Transport
Roads & Traffic
Authority

**STAGE 2 CONSTRUCTION OF A RESIDENTIAL BUILDING WITH BASEMENT CAR PARK
61 MOBBS LANE, EPPING**

25 August 2011

Parking Level 2 Plan

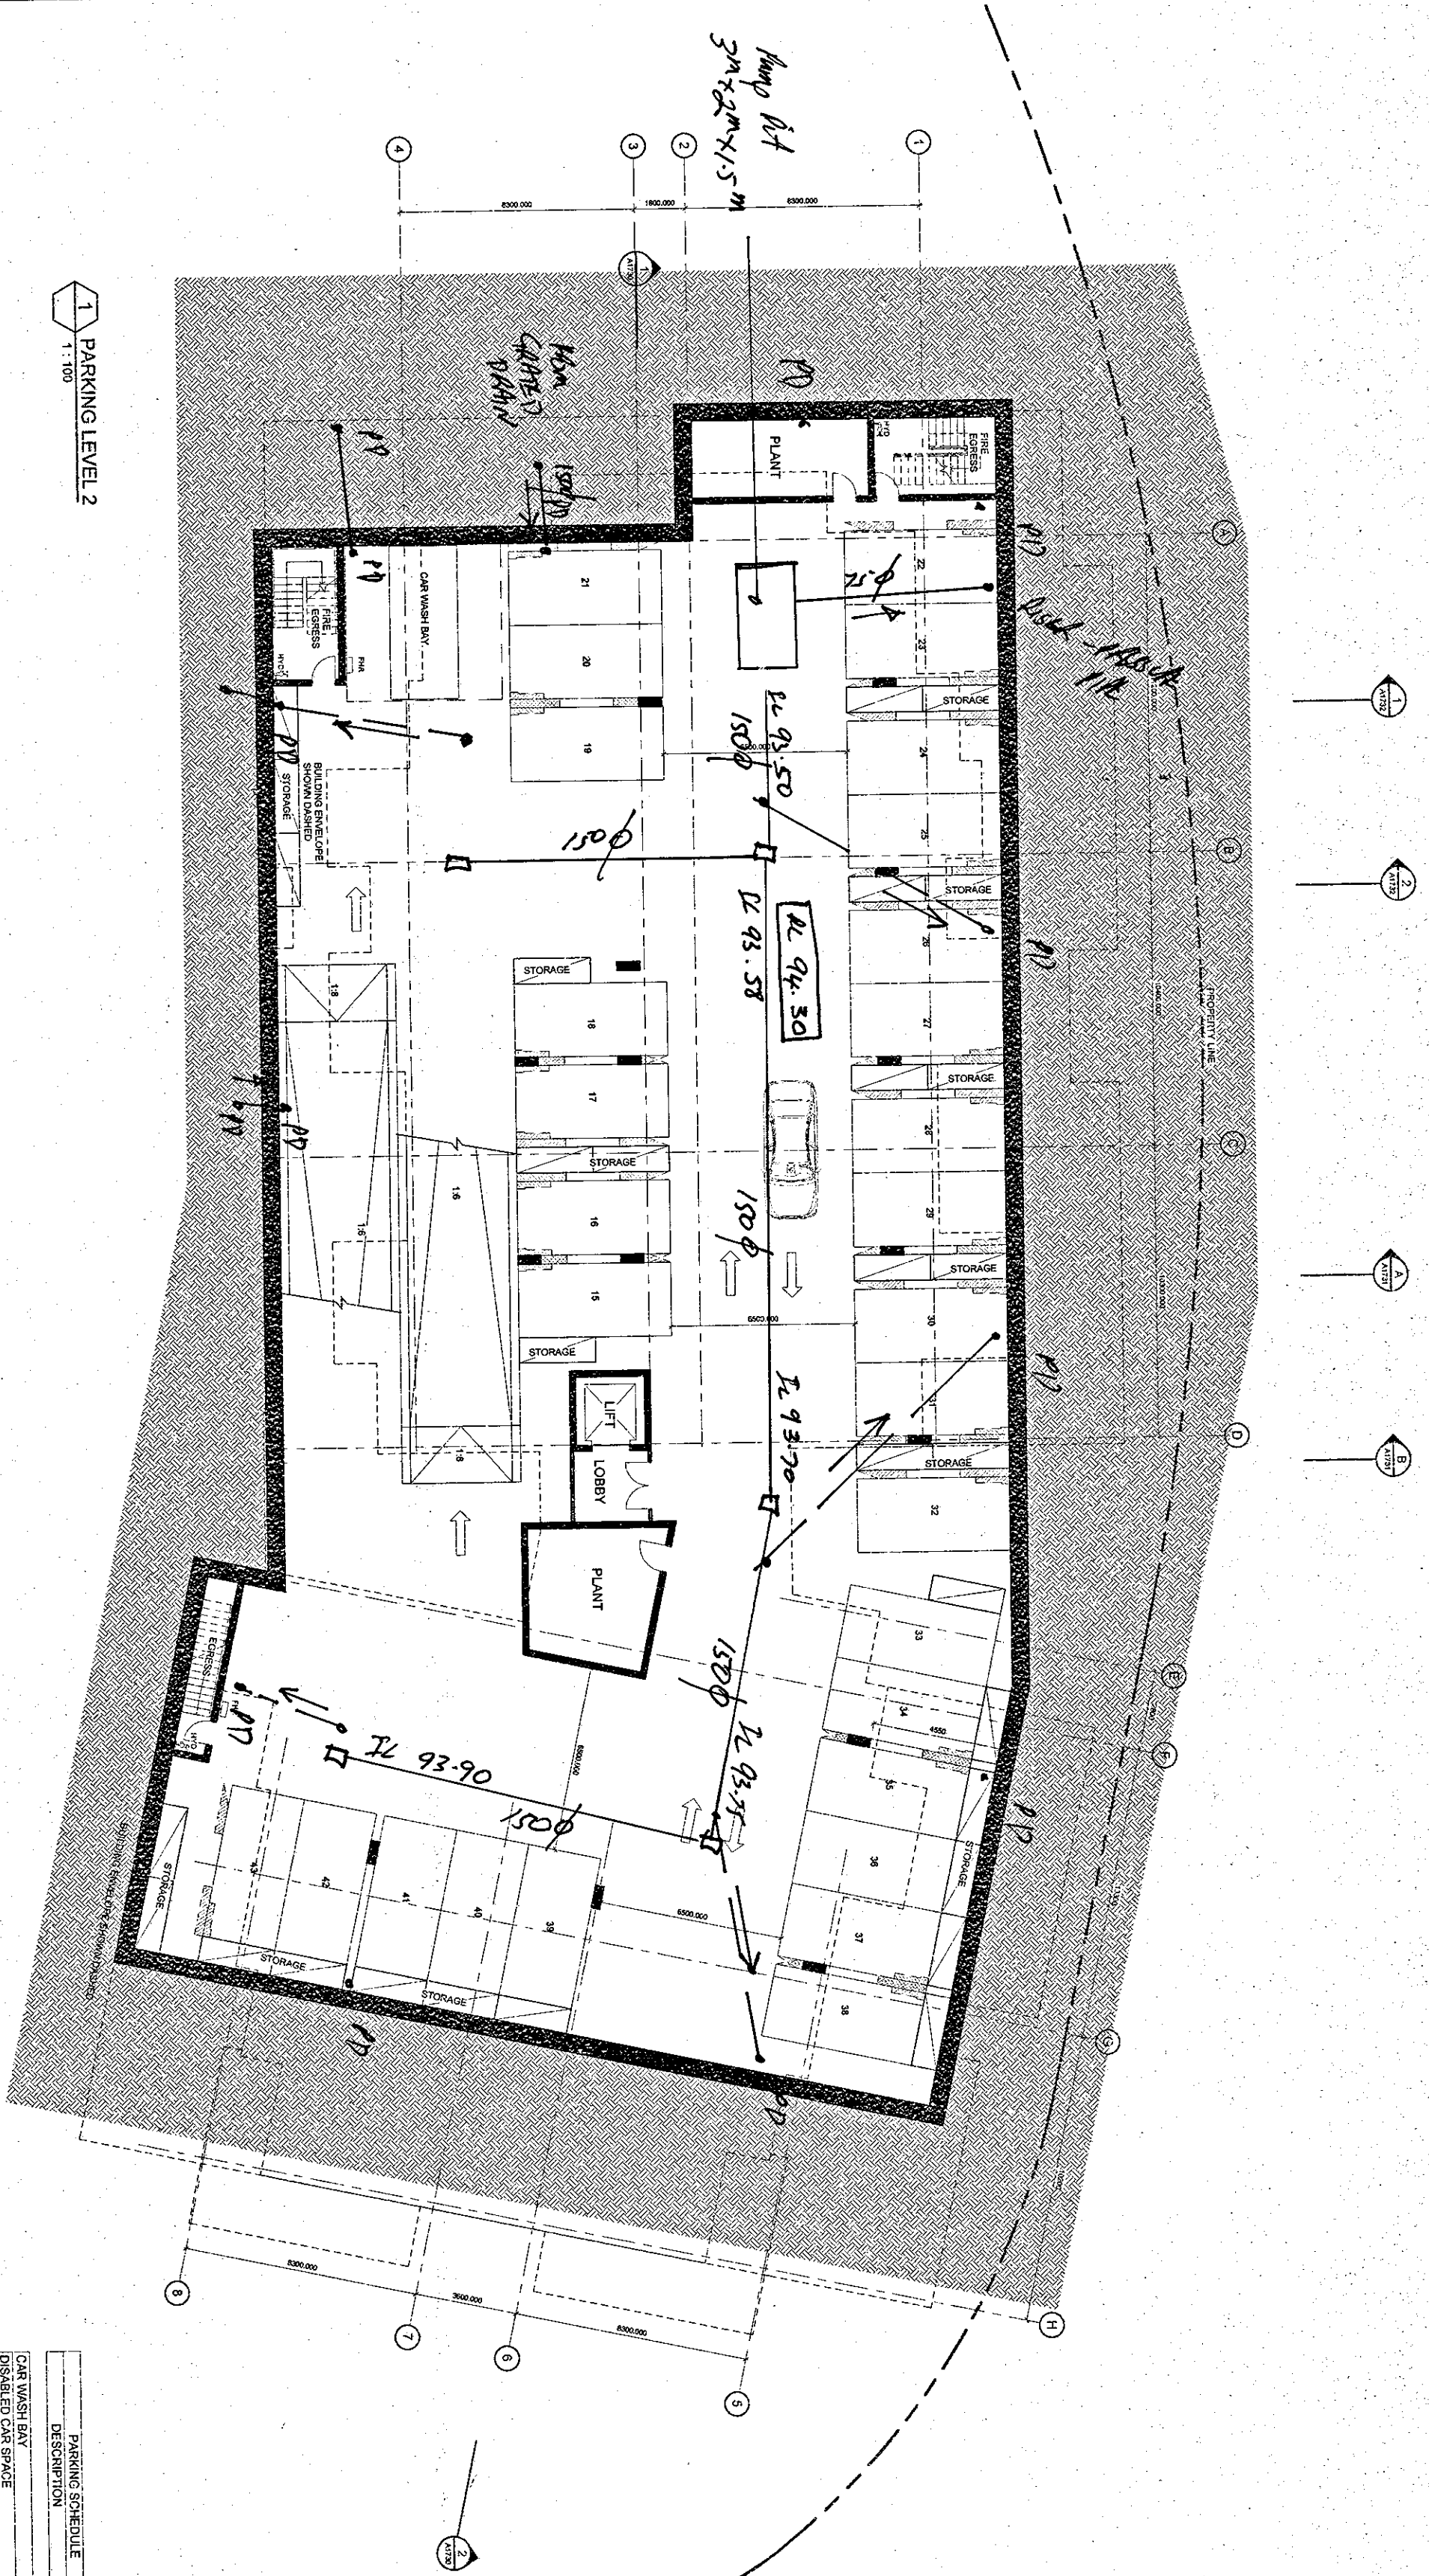
2. The DoPI should ensure that the layout of the proposed car parking areas associated with the subject development (including, driveways, grades, turn paths, sight distance requirements, aisle widths, aisle lengths, and parking bay dimensions) are in accordance with AS 2890.1 - 2004 and AS 2890 - 2002 for heavy vehicles.

3. The circulation ramps should be in accordance with AS 2890.1 - 2004 and to DoPI's satisfaction.
4. The turning paths for waste collection vehicles entering the bin collection area have not been shown on the submitted plans. The access roads should be wide enough to ensure that they will accommodate the turning paths of the proposed maximum sized vehicle that will utilise the access when entering and exiting the subject site.

6. The minimum available headroom clearance is to be signposted at all entrances and clearance is to be a minimum of 2.2 metres (for cars and light vans, including all travel paths to and from parking spaces for people with disabilities) measured to the lowest projection of the roof (fire sprinkler, lighting, sign and ventilation), according to AS 2890.1 - 2004.

7. It is not clear where the waste collection will occur. If the waste is to be collected from basement areas the basement should be high enough to accommodate waste service vehicles. The access roads should be wide enough to ensure that they will accommodate the turning paths of the proposed maximum sized vehicle that will utilise the access when entering and exiting basements.

8. Turning areas should be provided at dead-end isles within basement car parks. These turning areas within the car park are to be kept clear of any obstacles, including parked cars, at all times.
